Application Ref:	3/2025/0753			 Ribble Valley Borough Council www.ribblevalley.gov.uk
Date Inspected:	16/10/25	Site Notice:	N/A	
Officer:	LW			
DELEGATED ITEM FILE REPORT:				REFUSAL

Development Description:	Proposed two-storey side extension and entrance canopy.
Site Address/Location:	22 Clitheroe Road, Whalley, BB7 9AB.

Existing North West Facing Elevation Scale 1:100

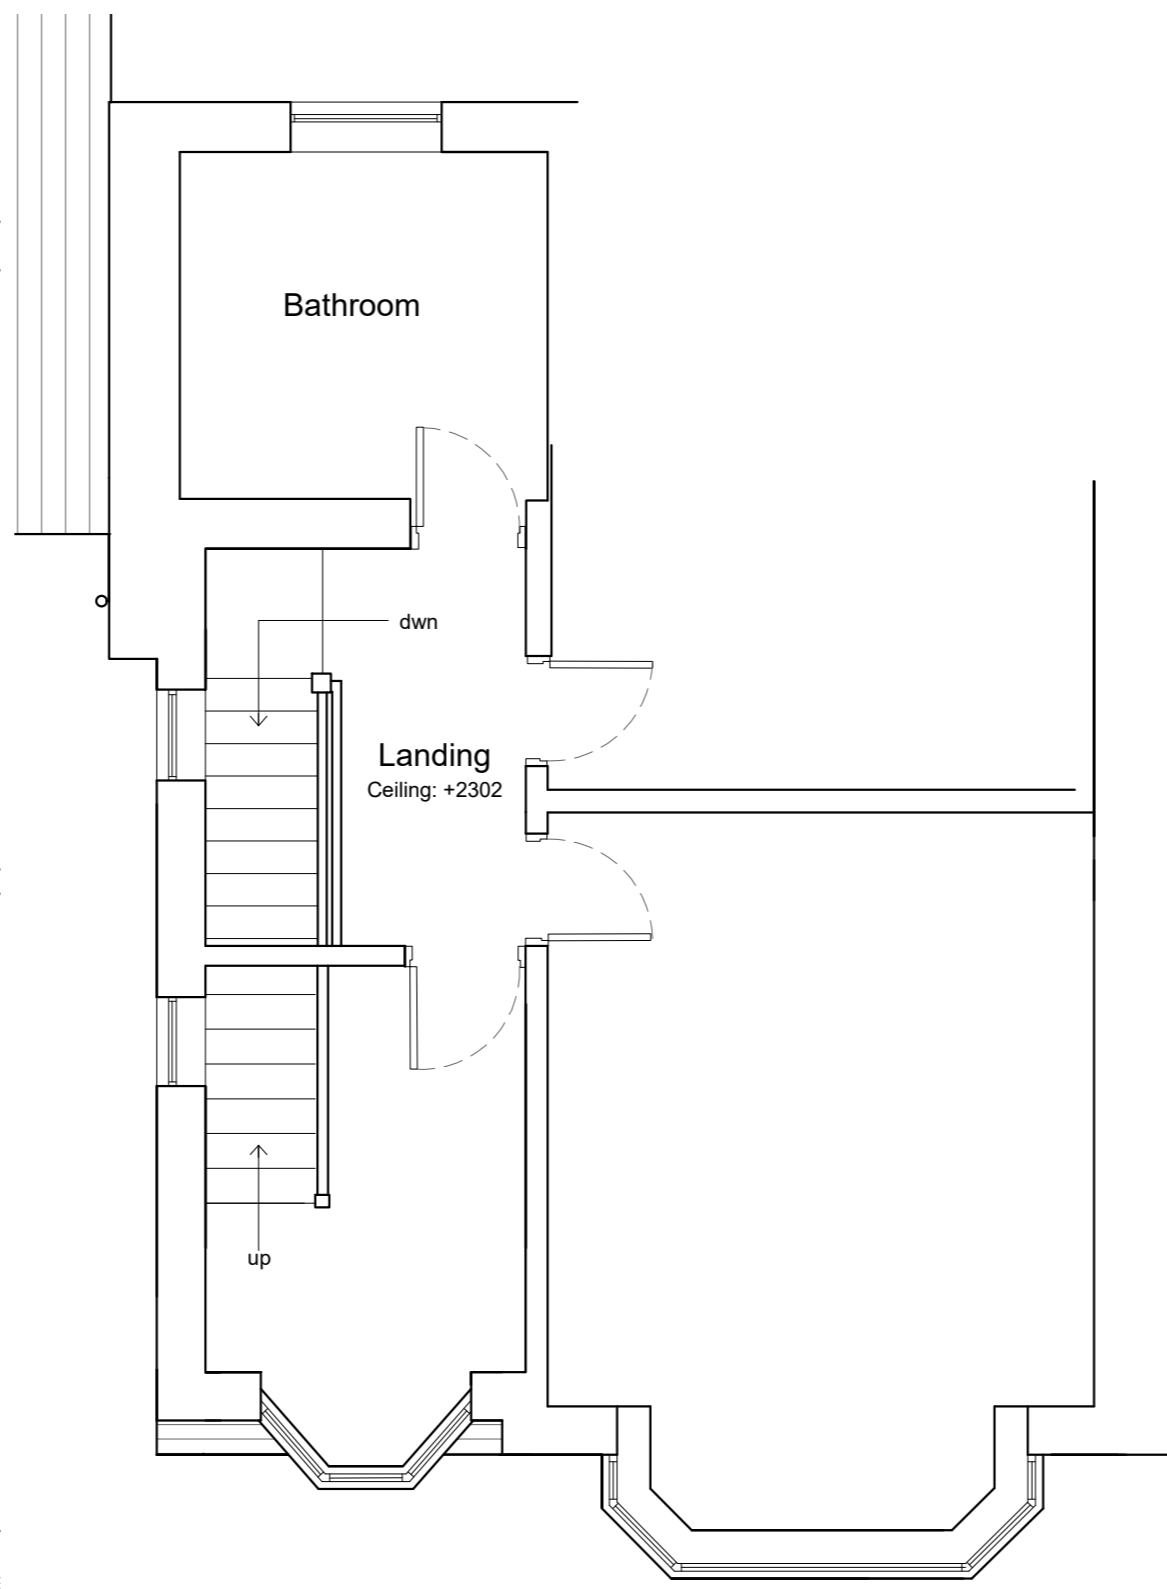
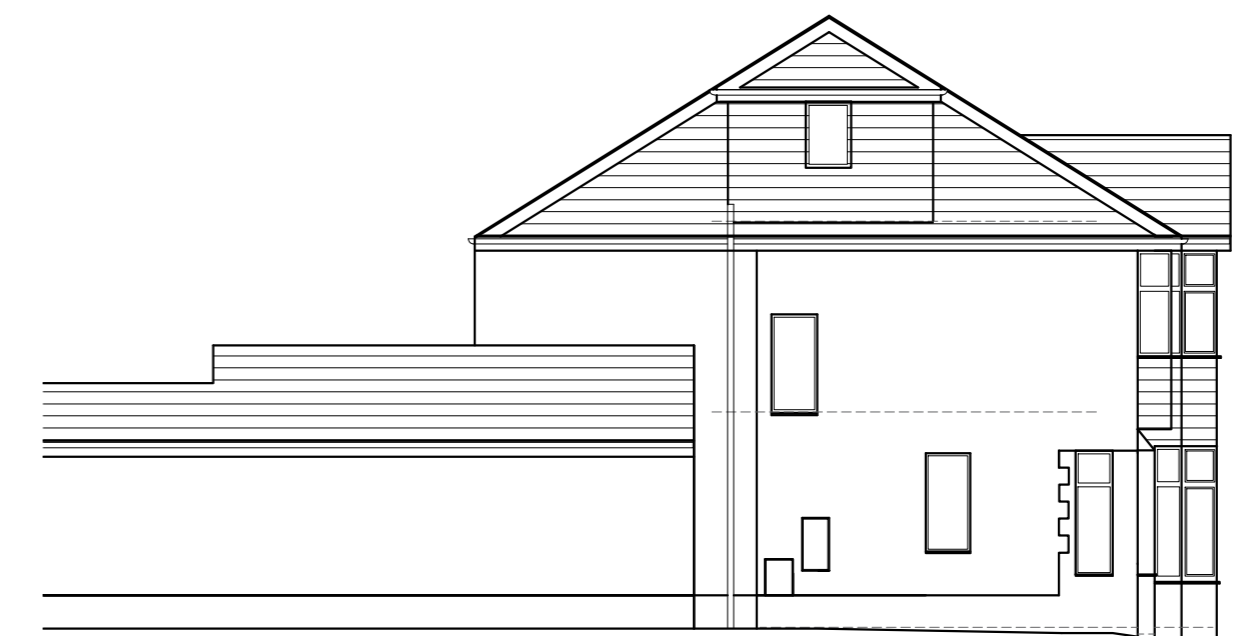
With respect to the proposed two-storey side extension, this element of the development would be sited in close proximity to the common boundary with No.24 Clitheroe Road with the side extension proposed bringing the north-eastern side elevation of the host property 3.64m closer towards the south-western side elevation of No.24 Clitheroe Road. The south-western side elevation of No.24 Clitheroe Road benefits from multiple existing openings, as well as a single storey element which is substantially set back from the principal elevation of the dwellinghouse. Whilst many of the neighbouring openings are obscure glazed and appear to serve non-habitable rooms, the single storey element at No.24 Clitheroe Road contains 1no. window to both the south-western side and north-western front elevation which are understood to serve a habitable space.

In this instance, although a marginal 0.5m set back would be incorporated, the proposed two-storey side extension would feature a dual pitch, reverse gable roof form which would adjoin just below the eaves of the main dwellinghouse without disturbing the existing roof form. As a result of this, the proposal would not visually integrate with the existing built form of the application property and would instead read as a disconnected two-storey garage structure sited directly adjacent to the main dwellinghouse. With this in mind and taking into account the existing relationship shared between the three pairings of semi-detached properties referenced above, it is considered that acceptance of a dual pitch, reverse gable two-storey side extension would result in detrimental harm to the visual amenities of both the application property and wider street scene.
